Sterling Ranch East Filing No. 6
Traffic Impact Study
PCD File No. P2414 and SP244
(LSC #S244251)
March 20, 2025

LSC Responses to TIS Redline Comments

N:\118380\DRAWINGS\CONSTRUCTION\33-118380-SIGNAGE-PLAN.dwg, 5/12/2026 3:39:23 PM, 1:1, KS

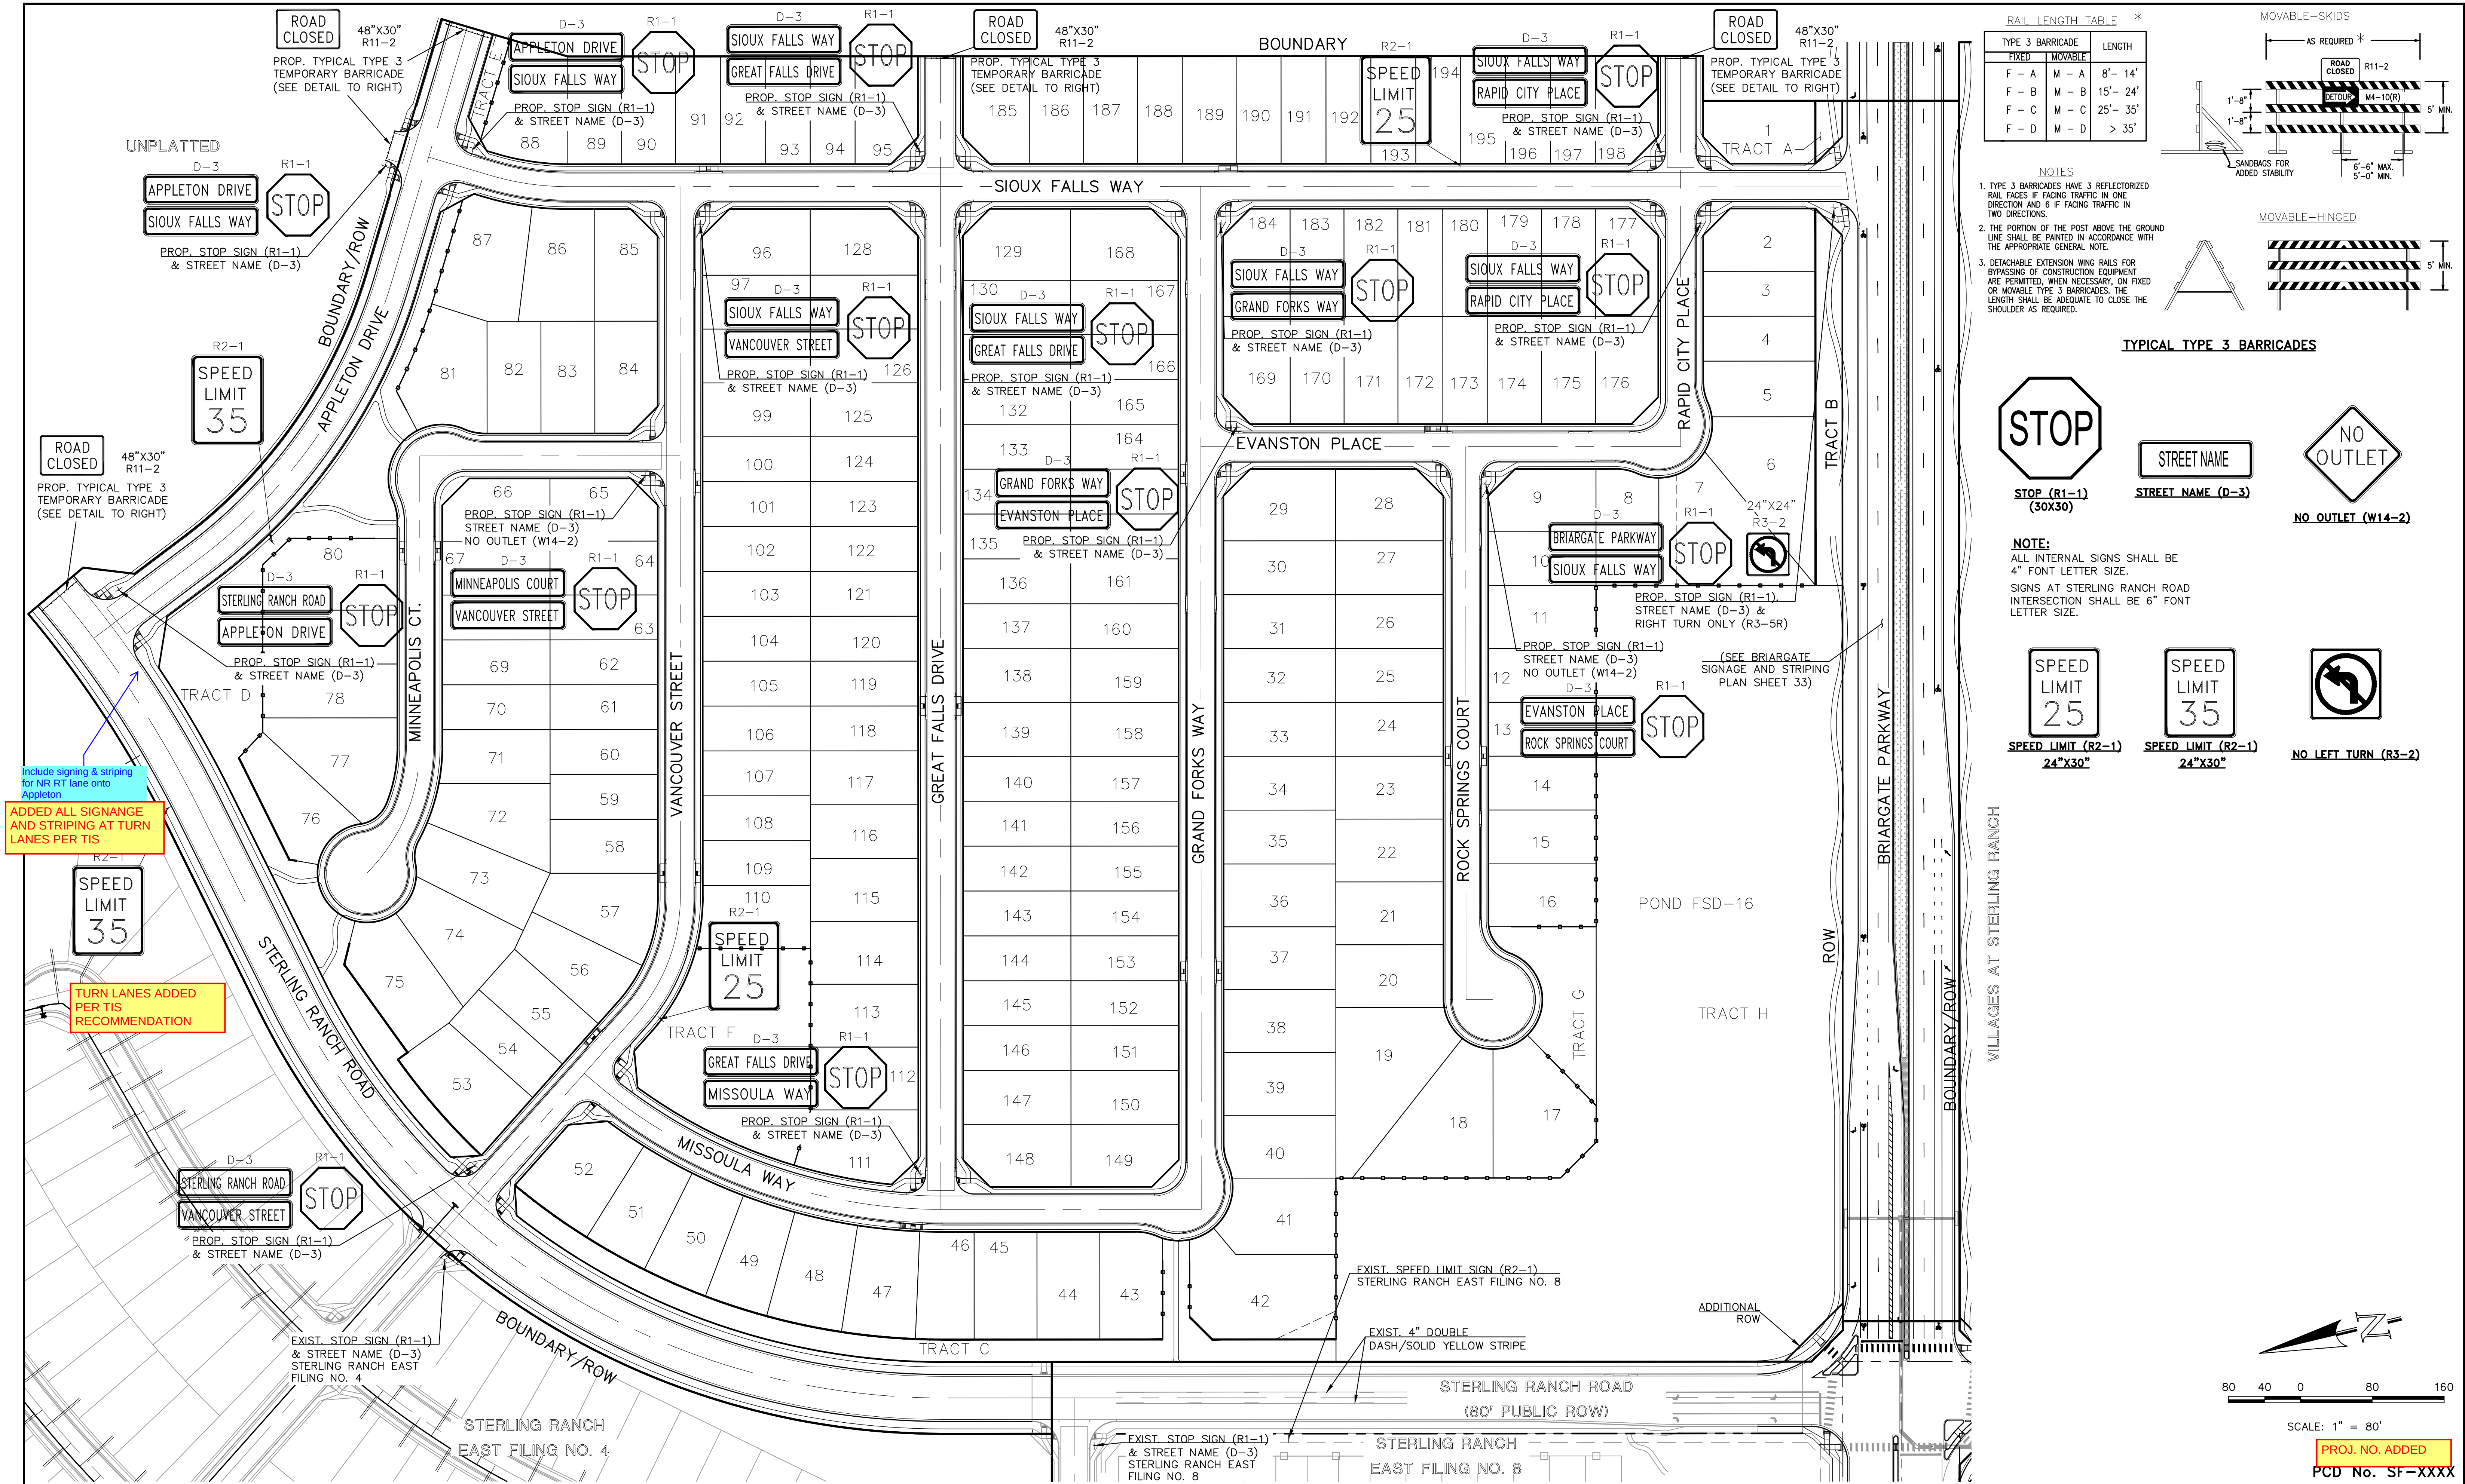
Provide discussion on all turn lanes needed. Include: northbound RT on Sterling Ranch to Briargate, westbound RT on Briargate to Sterling Ranch, eastbound RT on Briargate to Sioux Falls & Northbound RT on Sterling Ranch to Appleton

LSC Response: Revised as requested
